# CITY OF PORTLAND, MAINE

April 28, 2015

Project Name:	May Street Townhouses	Project ID:	2014-149
Address:	7-9 May Street	CBL:	057 C023 001
Applicant:	May Street 7-9, LLC		
Planner:	Shukria Wiar

## MEMORANDUM

PLAN SHOWING
SUBDIVISION OF LAND
AT
7-9 MAY STREET, PORTLAND, MAINE
MADE FOR
OWNER OF RECORD
MAY STREET 7-9, LLC
MAILING ADDRESS:
6 POND RIDGE LANE, NORWALK, CT 06853
LIVINGSTON-HUGHES
PROFESSIONAL LAND SURVEYING CORPORATION
88 GUINEA ROAD, KENNEBUNKPORT, MAINE 04046

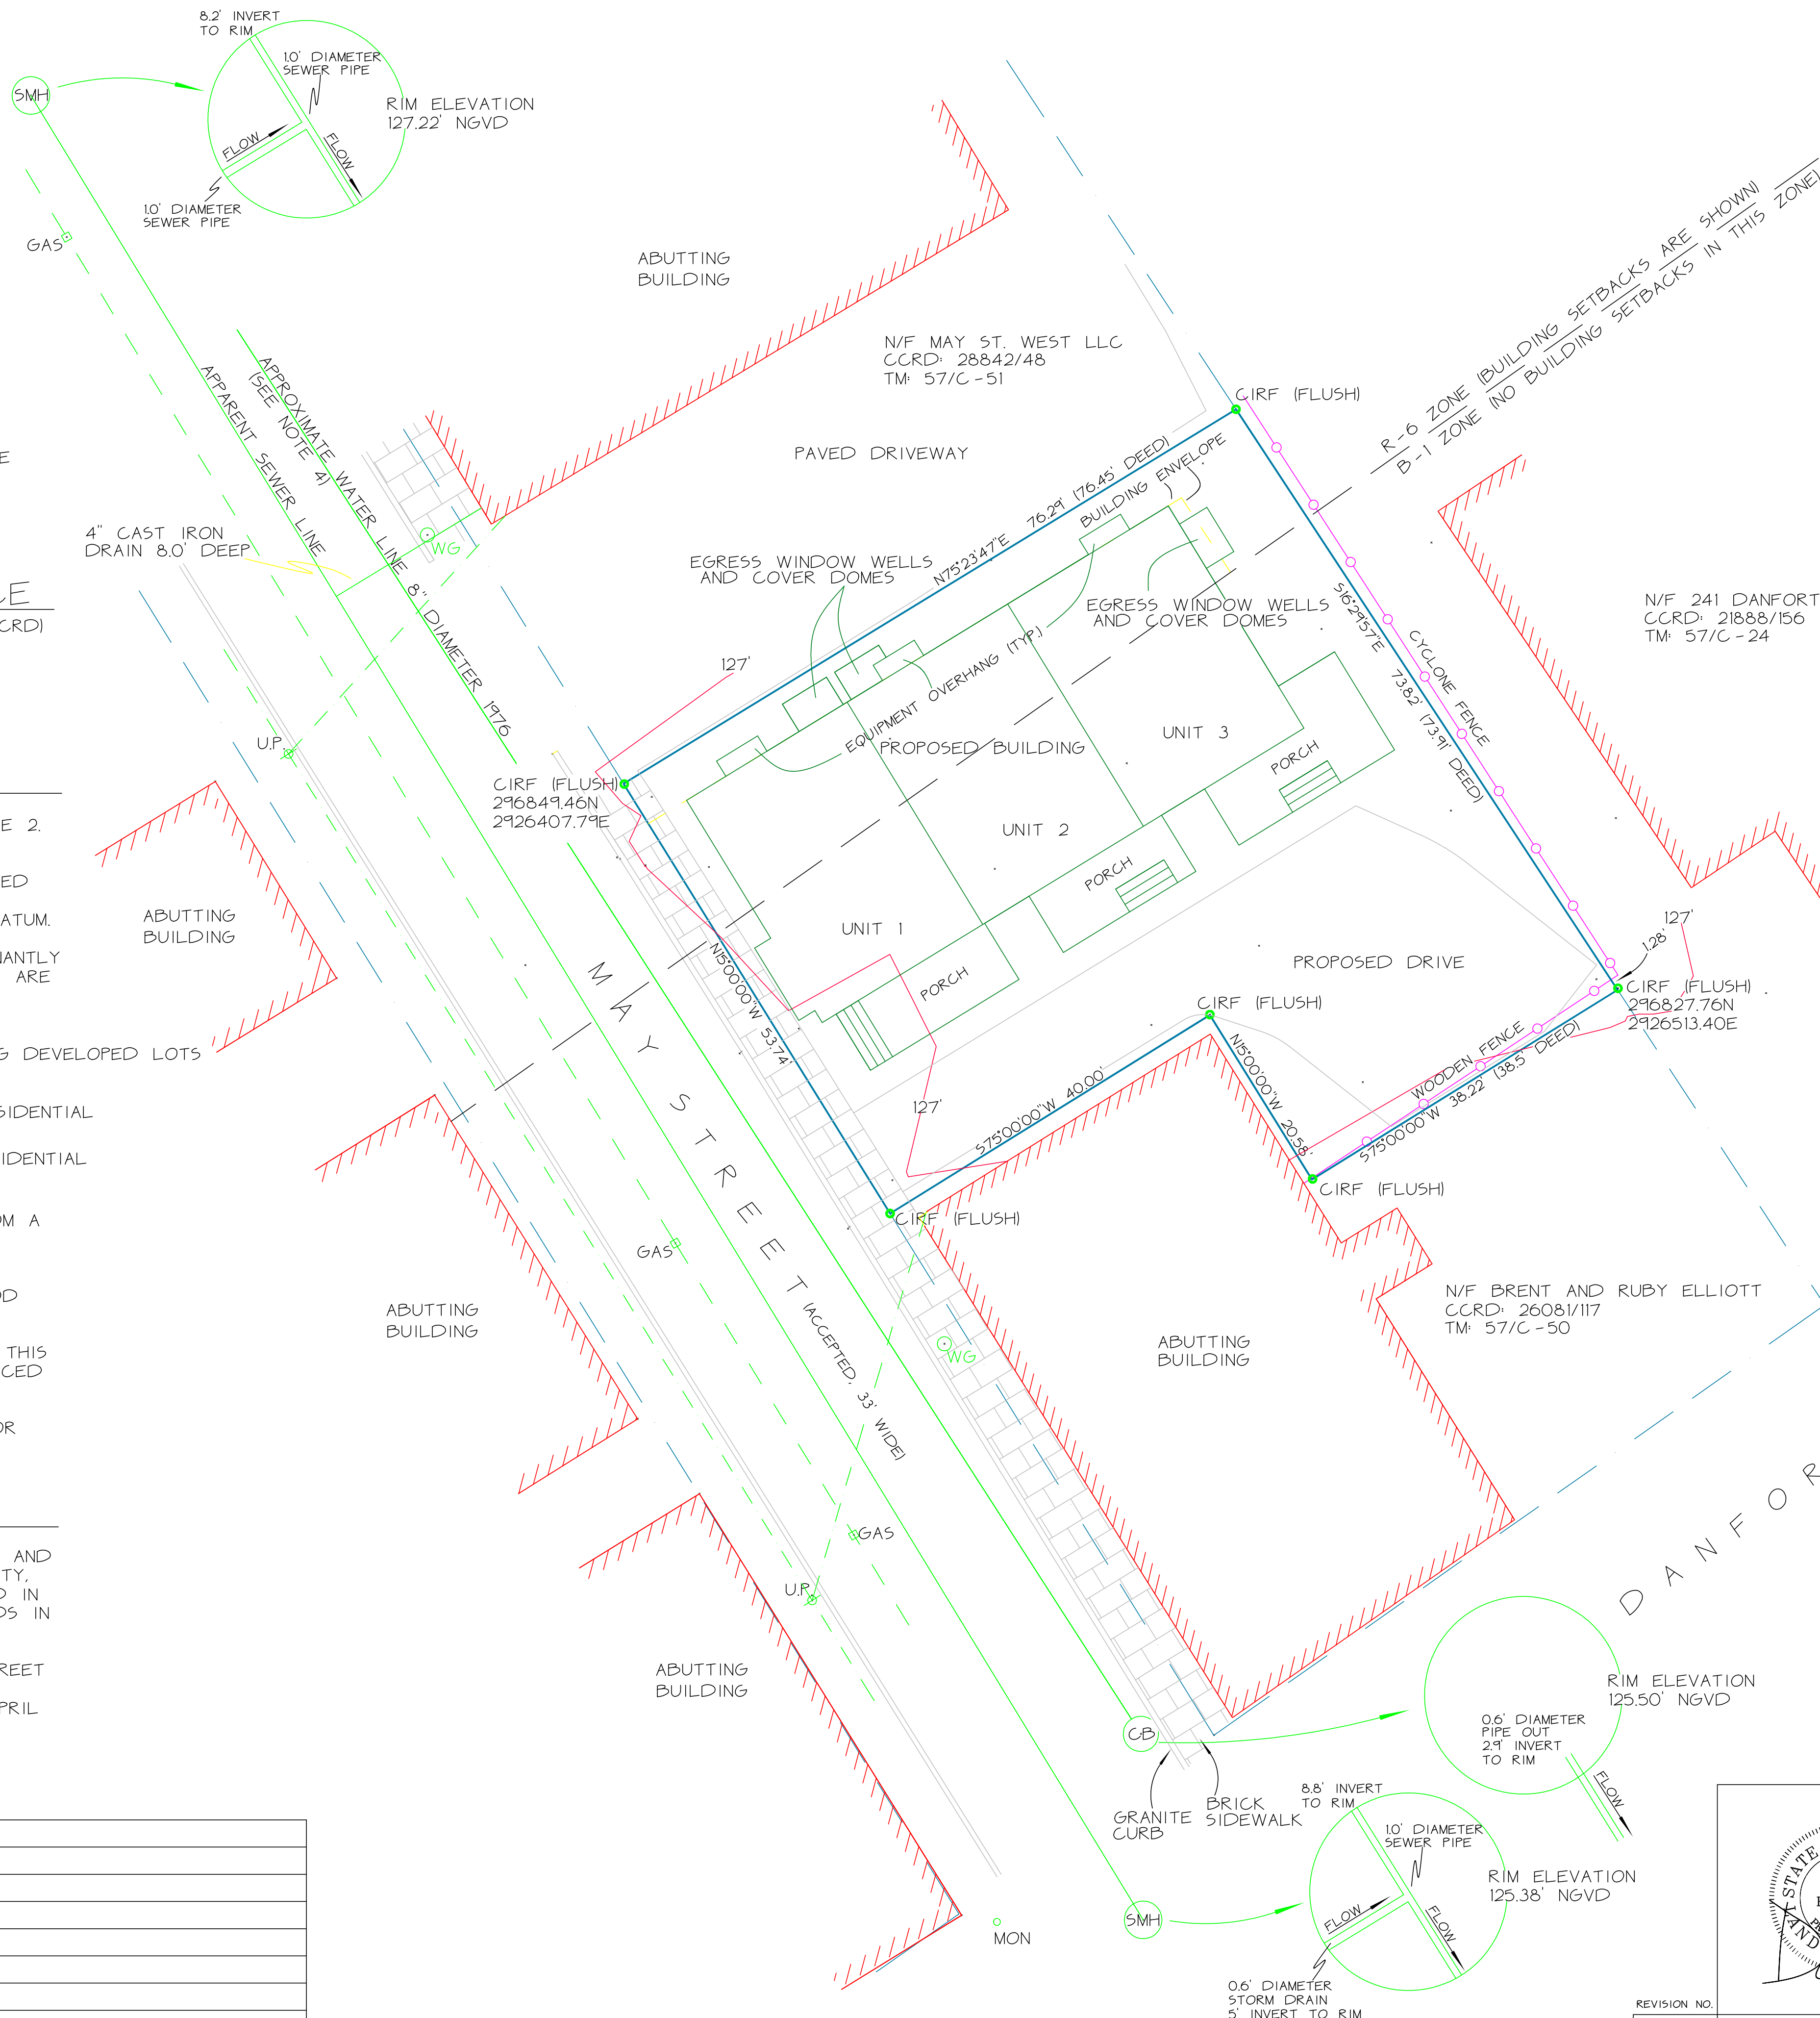
The applicant has submitted a recording plat. The plat will need to note the number of proposed units and associated parking on site. The final plat will need to be revised to reflect any waivers and conditions of approval that relate to the subdivision plan. Any waivers granted must be recorded at the Registry of Deeds within 90 days of a Planning Board decision.

1. That the final sidewalk easements to provide public access shall be reviewed and approved by Corporation Counsel prior to the issuance of certificate of occupancy; and
2. That the recording plat shall be revised noting all waivers and conditions for review and approval by the Planning Authority prior to recording. All waivers shall be recorded within 90 days of the Planning Board approval.

Drawing file: 1. Original Plans / WAT-C-1.2 CONCEPT SITE PLAN.pdf

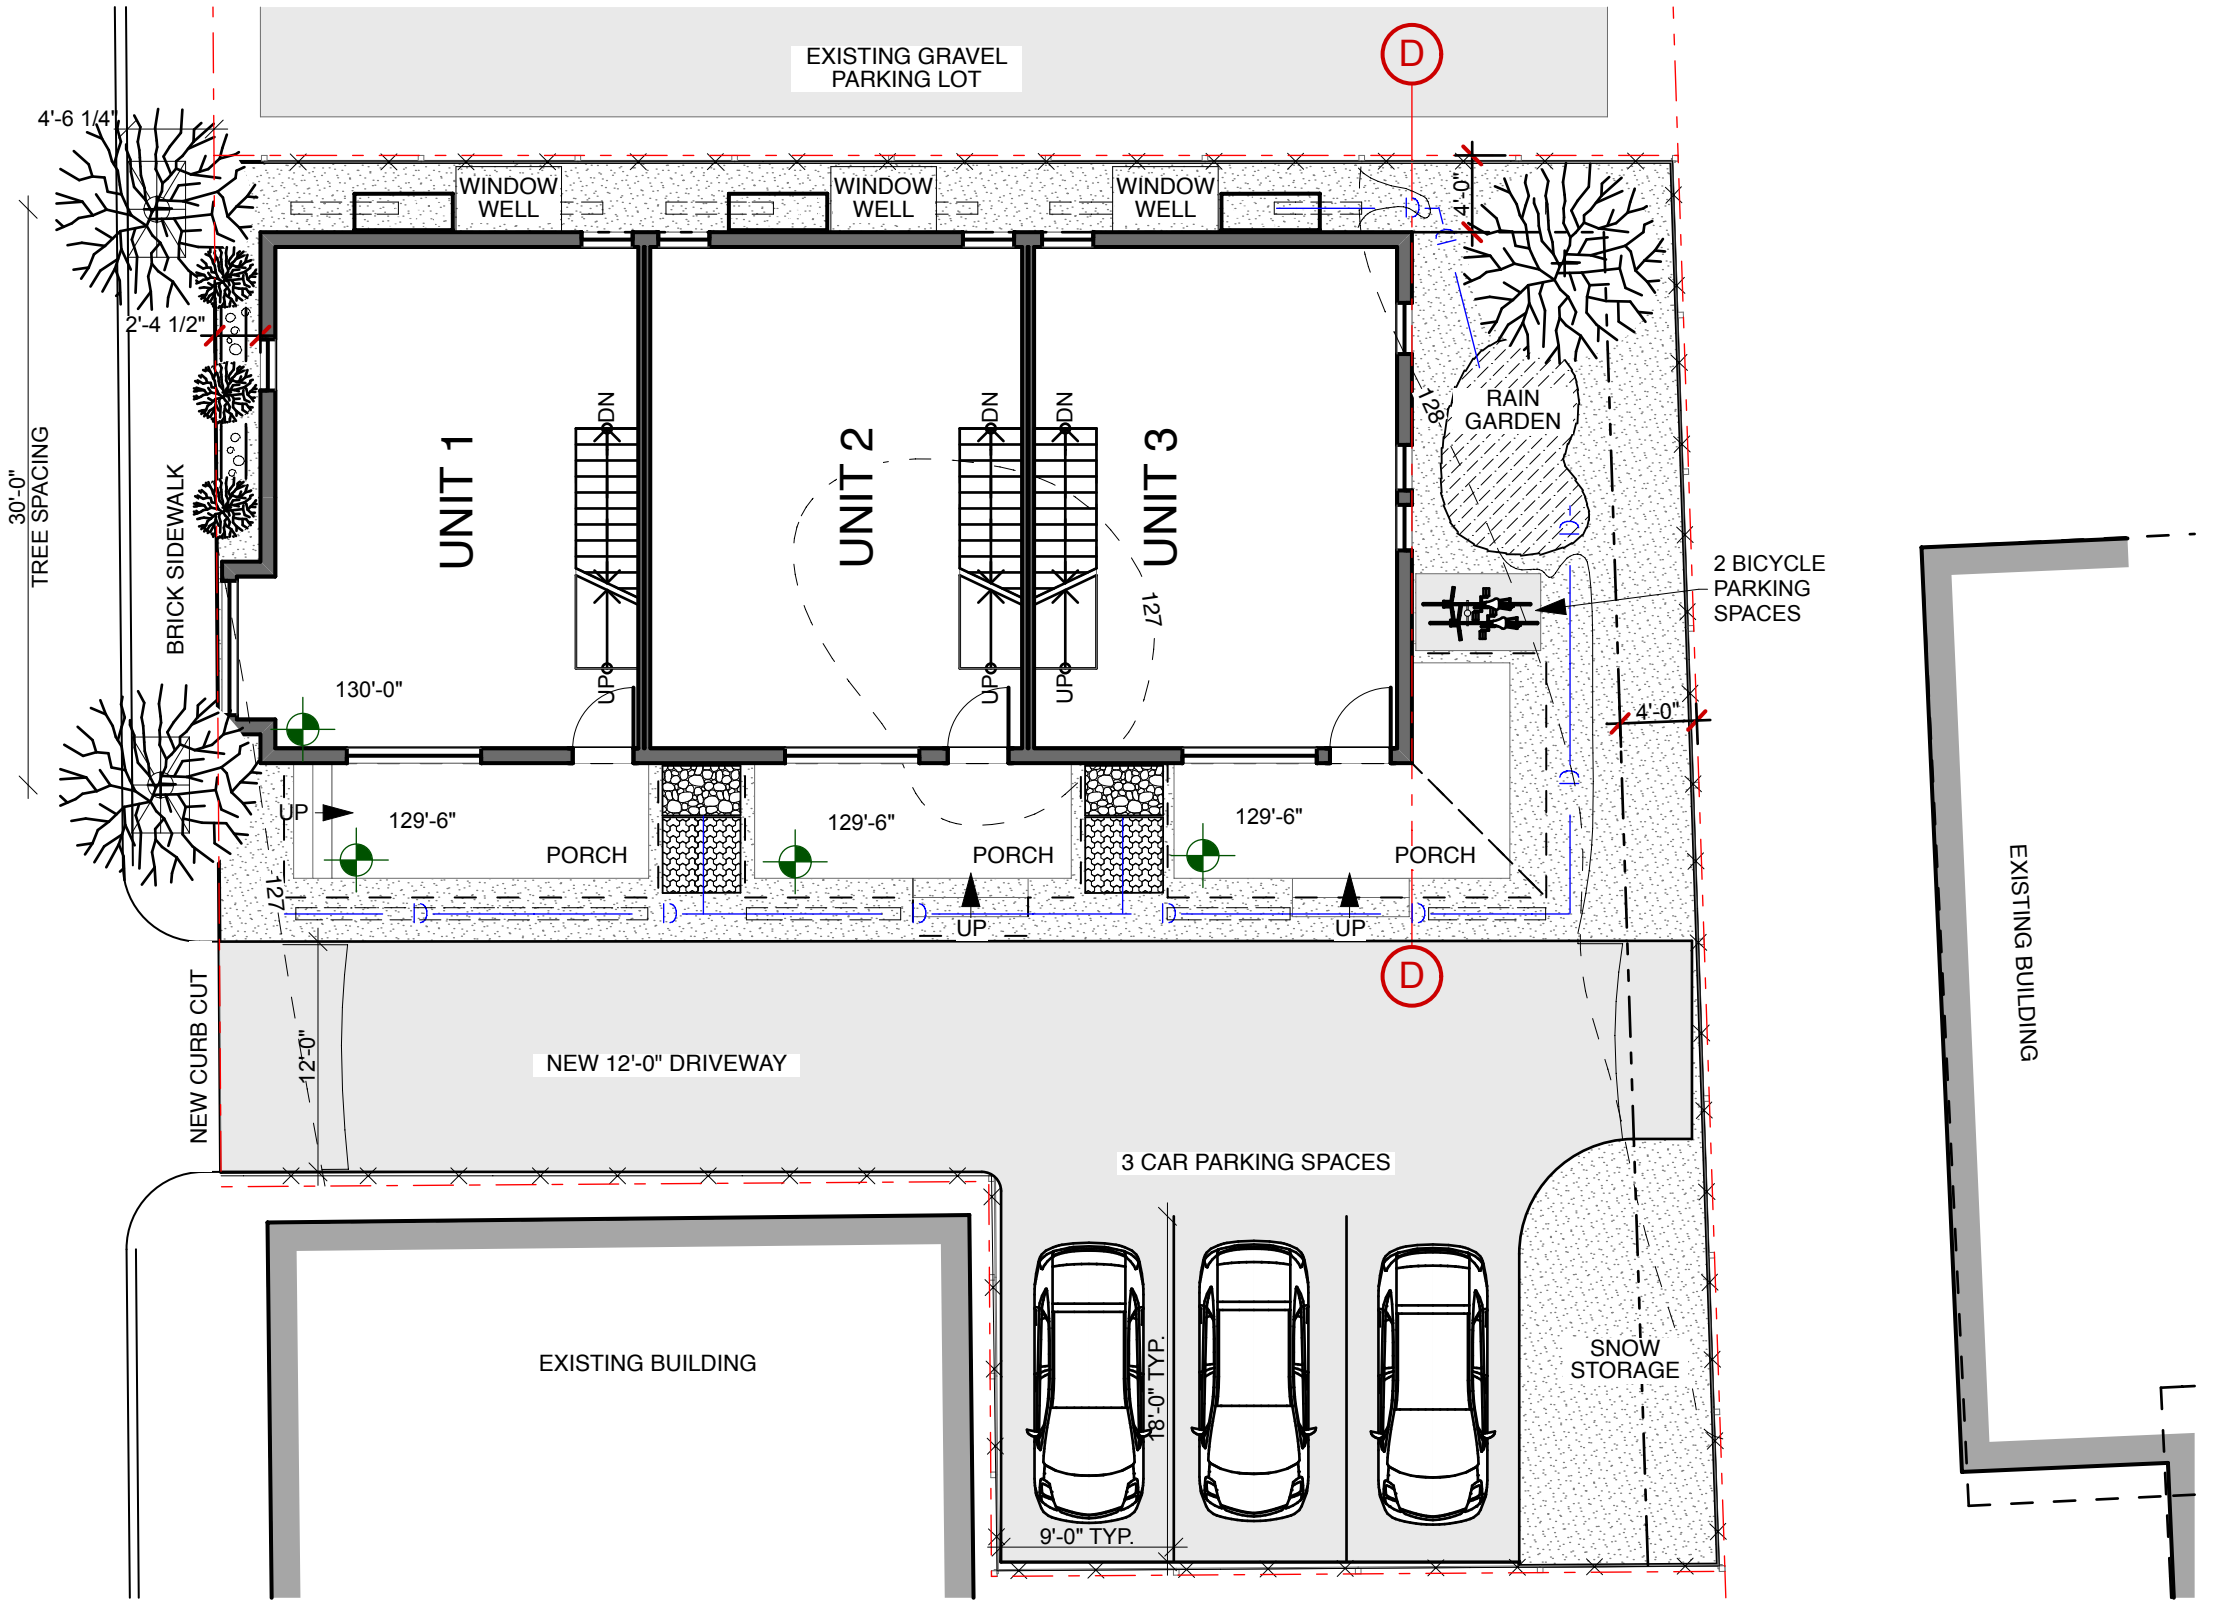
b) General Standards: The project will result in an increase in impervious area of approximately 3,600 square feet. As such, the project is required to include specific stormwater management features for stormwater quality control. The Applicant proposes a rain garden to manage stormwater quality on the site. Additional design details and calculations should be provided with the future Final Site Plan submittal demonstrating compliance with the General Standards (refer to Chapter 7.2 of Volume III of the MaineDEP Stormwater BMP Manual for rain garden design requirements).
